Preliminary and Final DRAINAGE PLAN AND REPORT **ROCKY TOP MOTEL AND CAMPGROUND**

County File No.: PPR2140

EPC STORMWATER REVIEW COMMENTS
IN ORANGE BOXES WITH BLACK TEXT

SUBJECT: Drainage Plan and Report
Rocky Top Motel and Campground

WEST SFB DETAILS

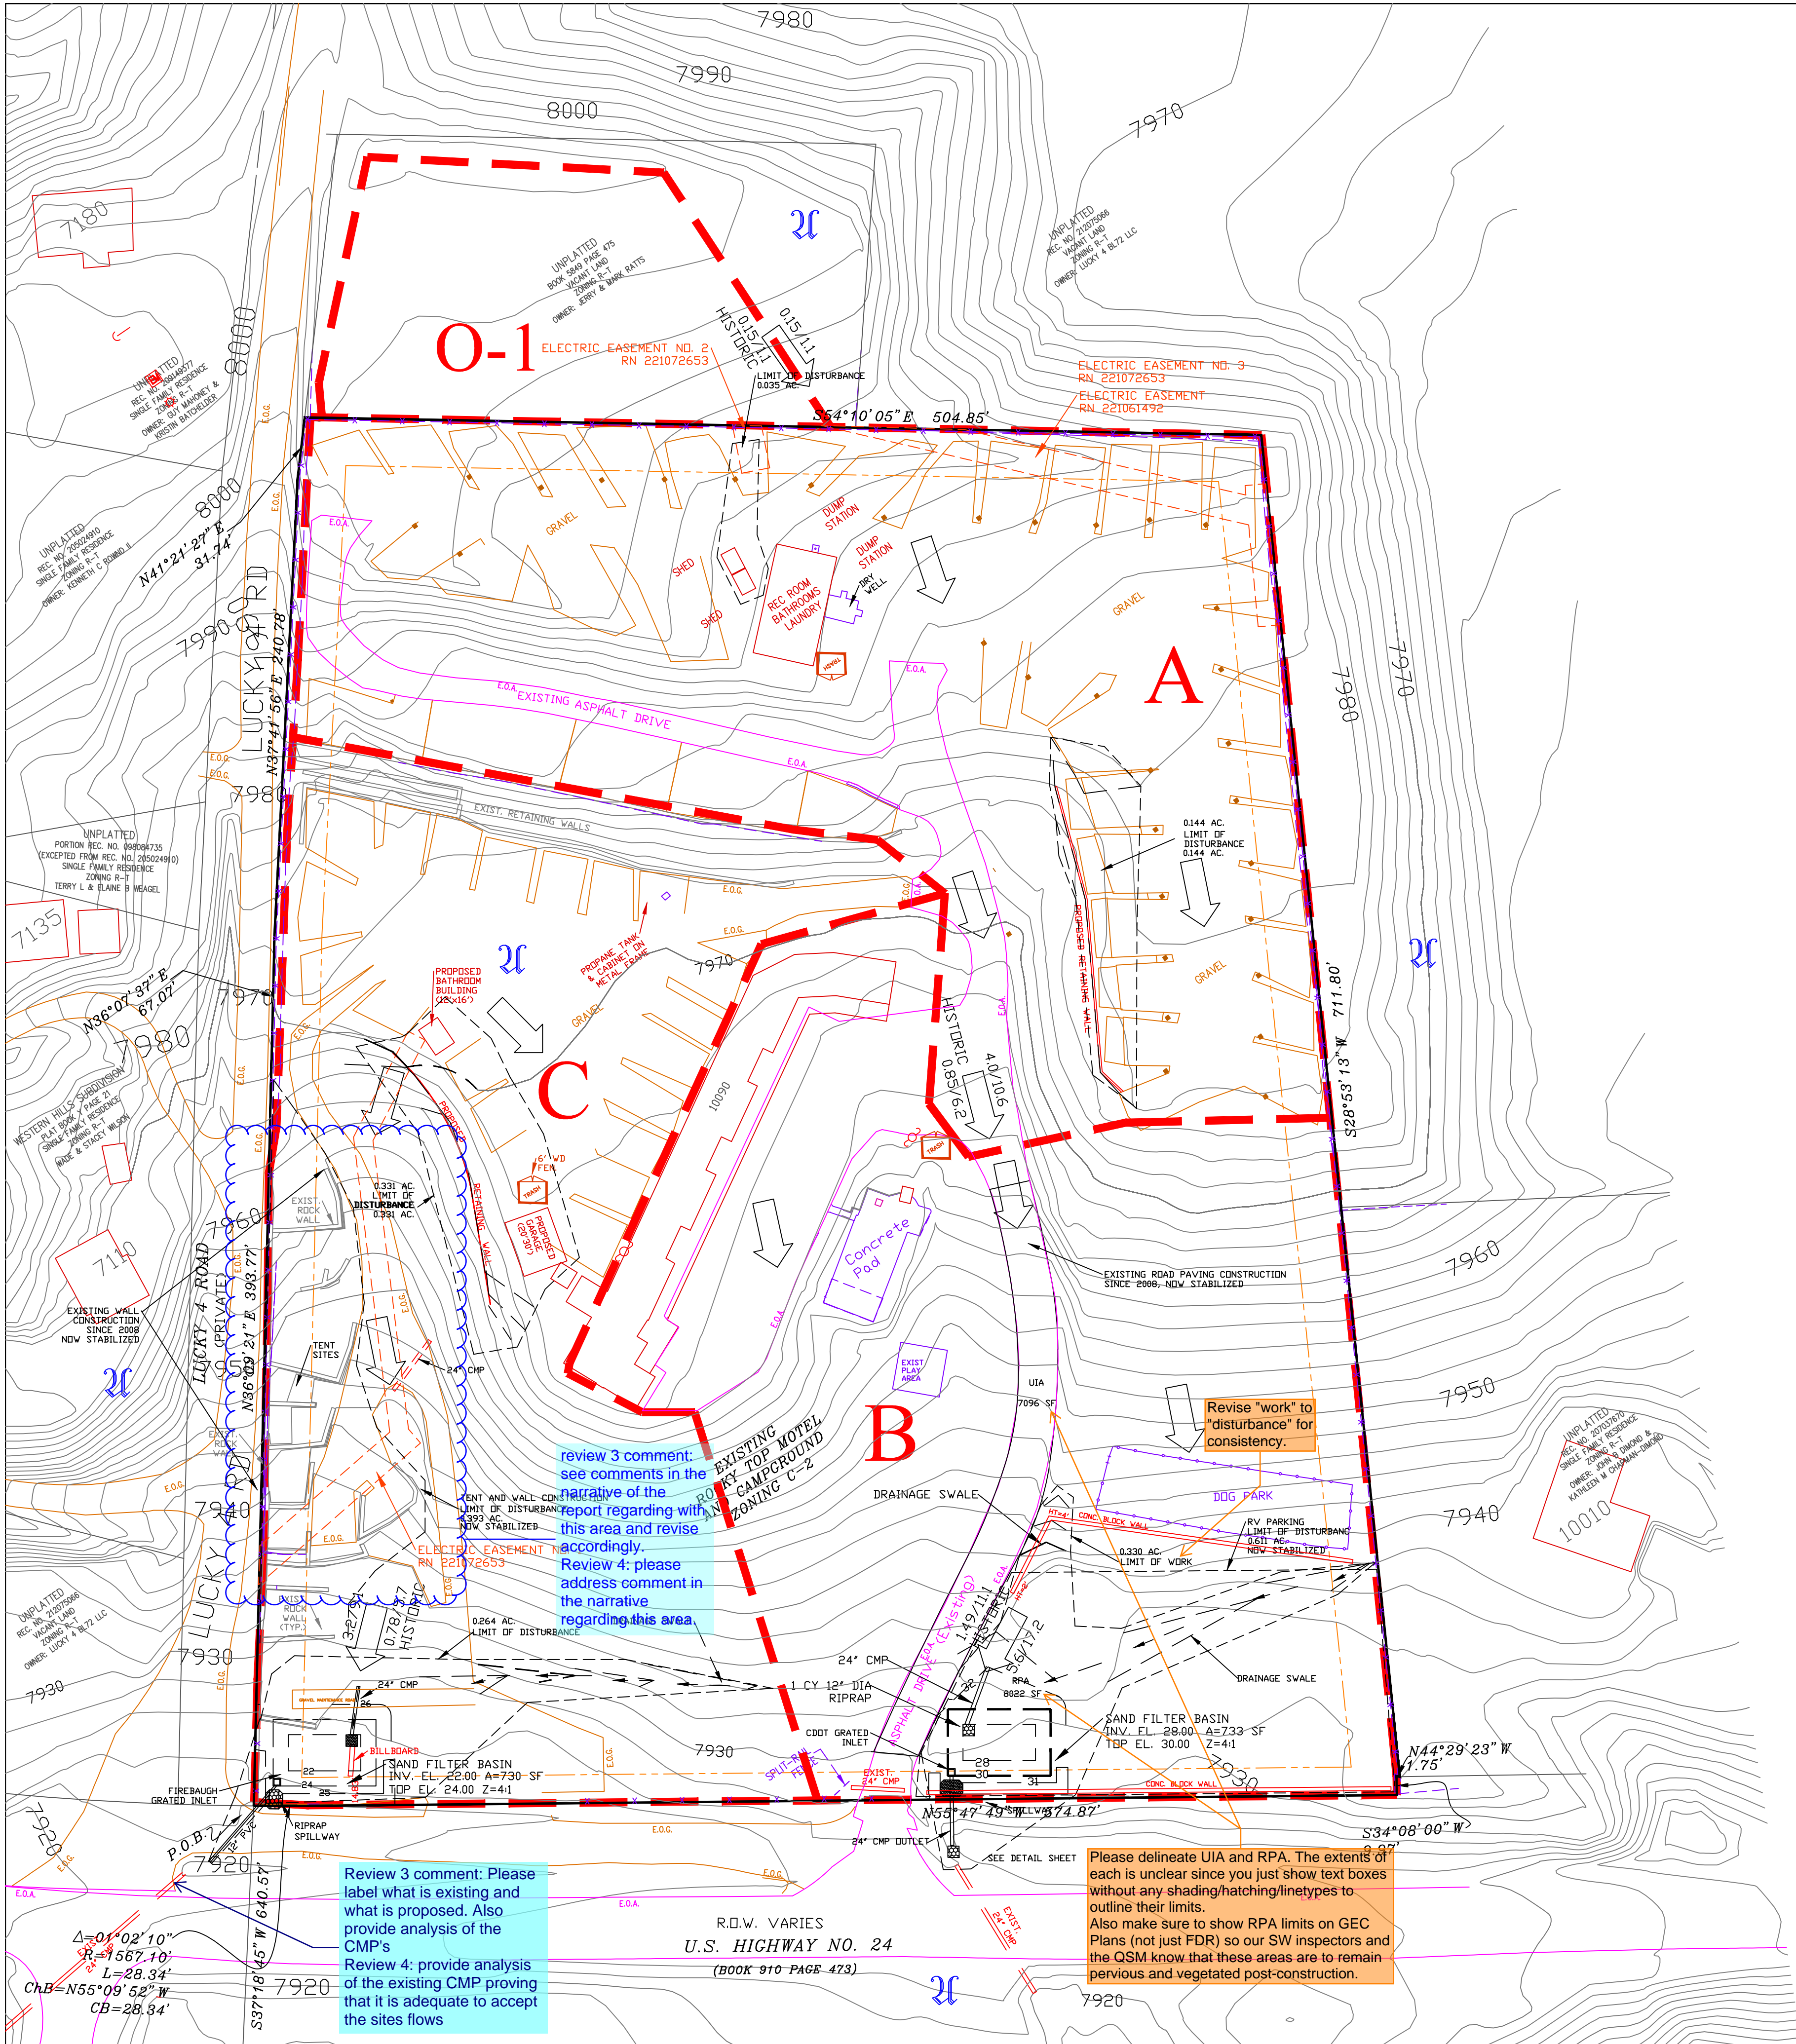
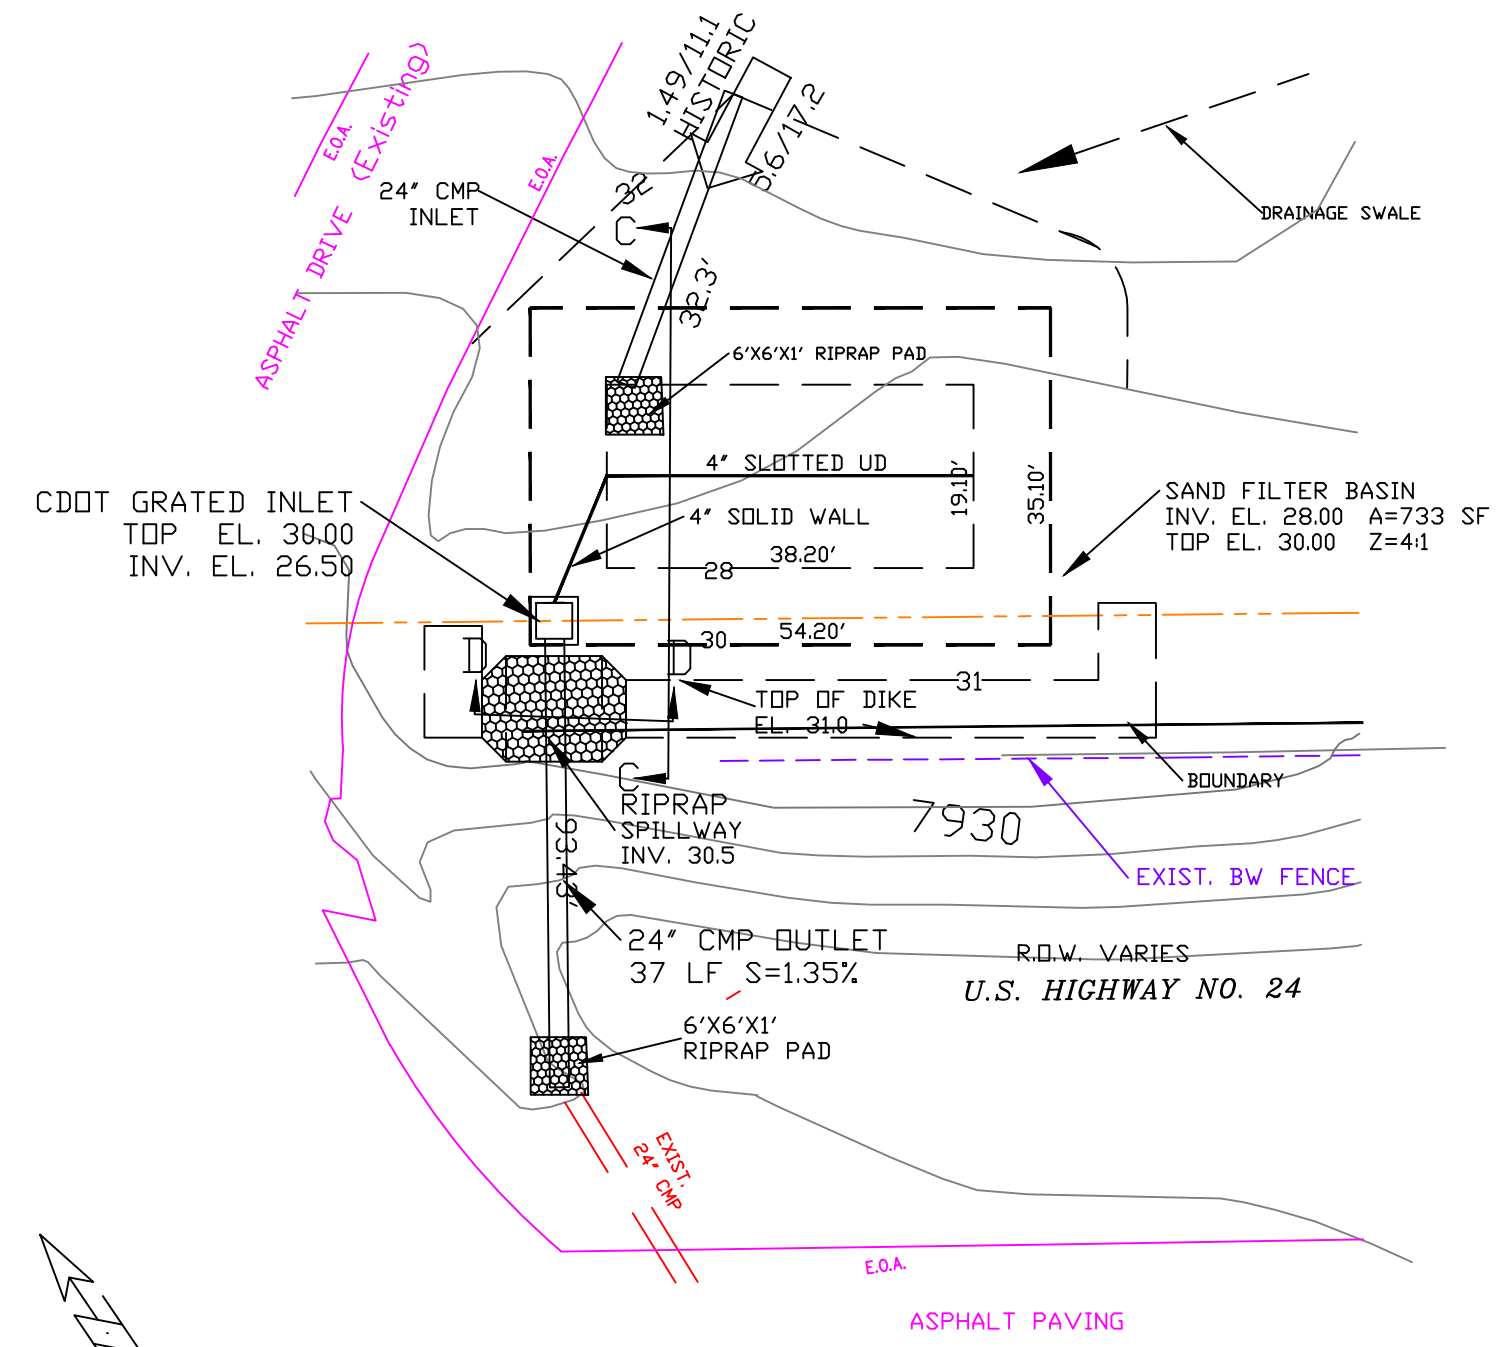
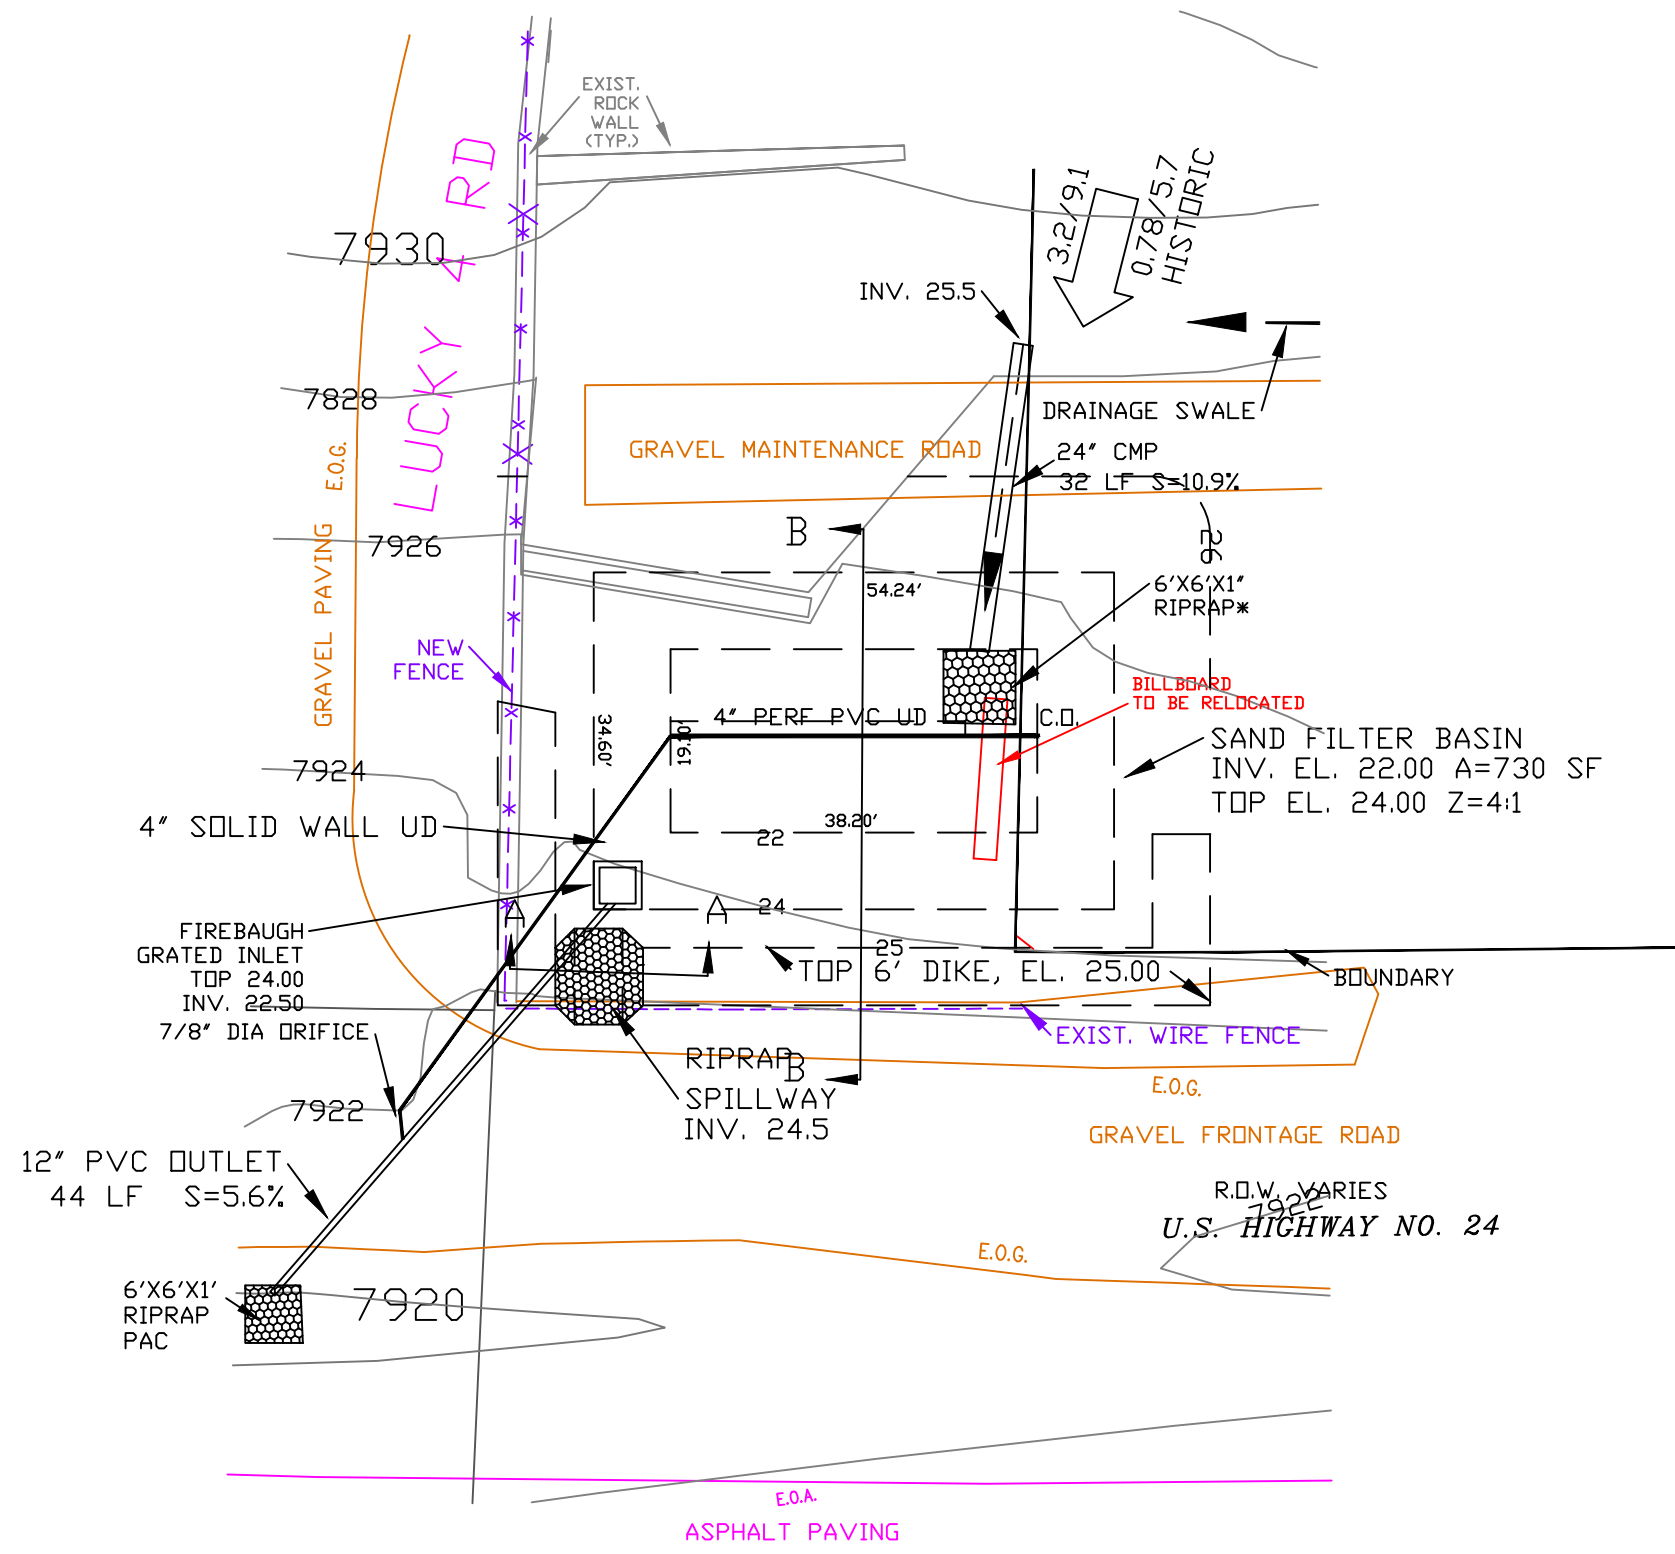
1.5ft here does not match what is shown on the plans. The plans show the bottom of the pond at 22ft elevation and inv of 4" pipe at connection to 18" pipe at 20.74ft. So something isn't right. Revise calcs and/or plans as needed to remove this discrepancy.

Cannot confirm whether or now 1.5ft here does matches what is shown on the plans. The plans show the bottom of the pond at 28ft elevation and inv of 4" pipe at connection to inlet box is unknown (not shown in plans). Revise calcs and/or plans as needed to clarify and to reflect this 1.5ft distance.

ALL TERRAIN RESPONSE: NOT ADDRESSED. SAND FILTERS NO LONGER PROPOSED.

ALL TERRAIN RESPONSE: NOT ADDRESSED. SAND FILTERS NO LONGER PROPOSED.
